**WELWYN HATFIELD BOROUGH COUNCIL
EXECUTIVE DIRECTOR - PLANNING, PUBLIC PROTECTION AND GOVERNANCE**

DELEGATED APPLICATION

Application No: 6/2019/2065/HOUSE
Location: 4 Queen Bee Court Hatfield AL10 9PR
Proposal: Erection of single storey side, rear extensions following demolition of lean to
Officer: Mr Tom Gabriel

job no:	3172
project:	4 Queen Bee Court, Hatfield AL10 9PR
drw title:	Proposed Elevations- Sheet 1
drwg no:	3172/PL/005
rev:	01
date:	Aug 19
scale:	1:100@A3

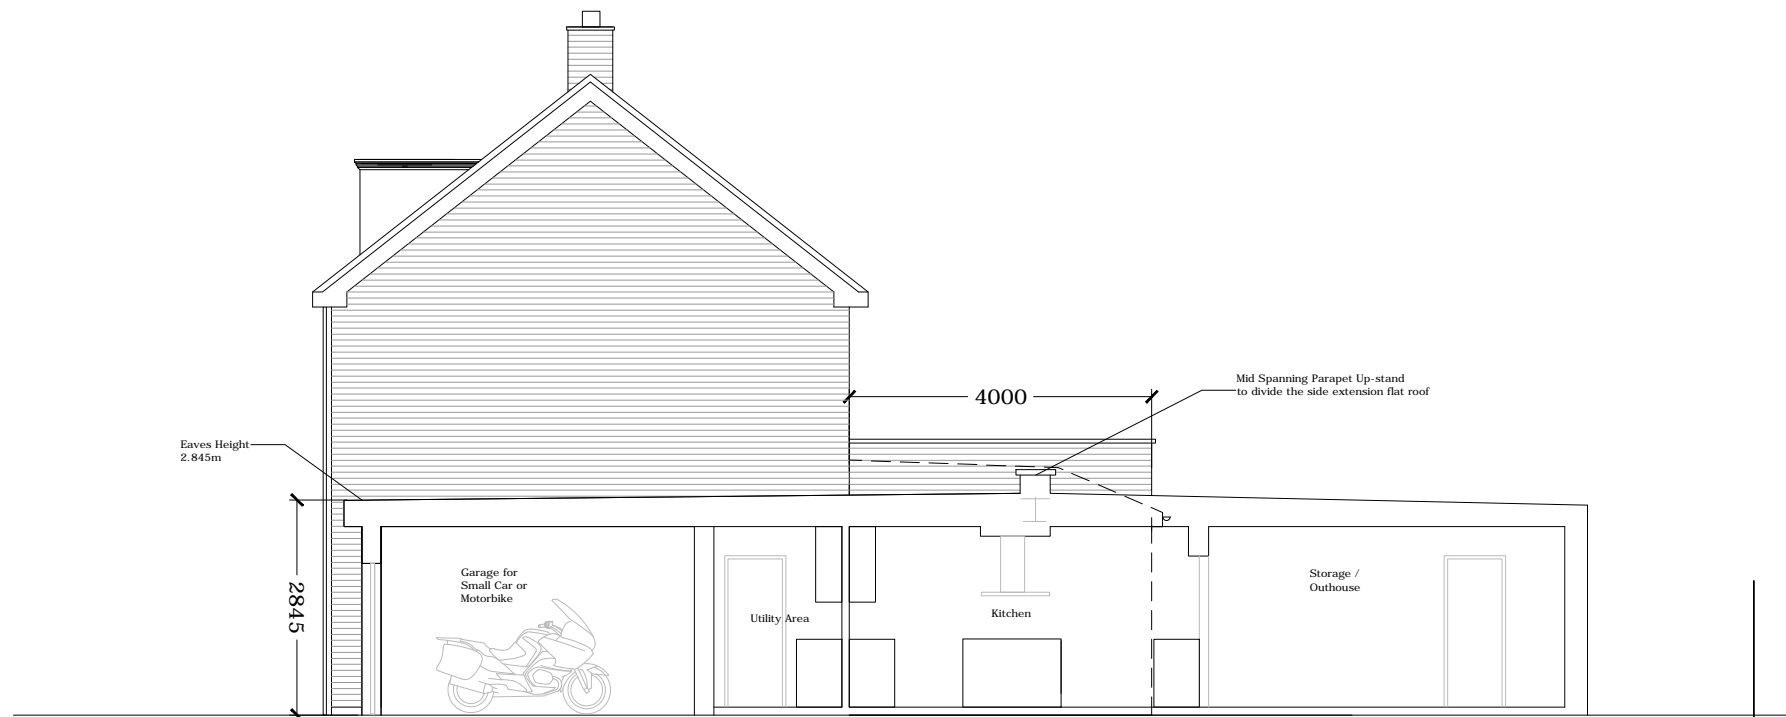
Would the development provide / retain sufficient parking?
<input checked="" type="checkbox"/> Yes <input type="checkbox"/> No <input type="checkbox"/> N/A Comment (if applicable): Following the erection of the extension, three car parking spaces would remain within the curtilage of the dwelling (following clarification of the extent of the curtilage of the property) in accordance with the Council's Car Parking Standards.
Conclusion
The proposed development is considered acceptable in respect of its relationship to the existing, dwelling, its impact upon the character and appearance of the area and neighbour amenity. Highway safety would not be harmed by the proposed development. The application is therefore recommended for approval.
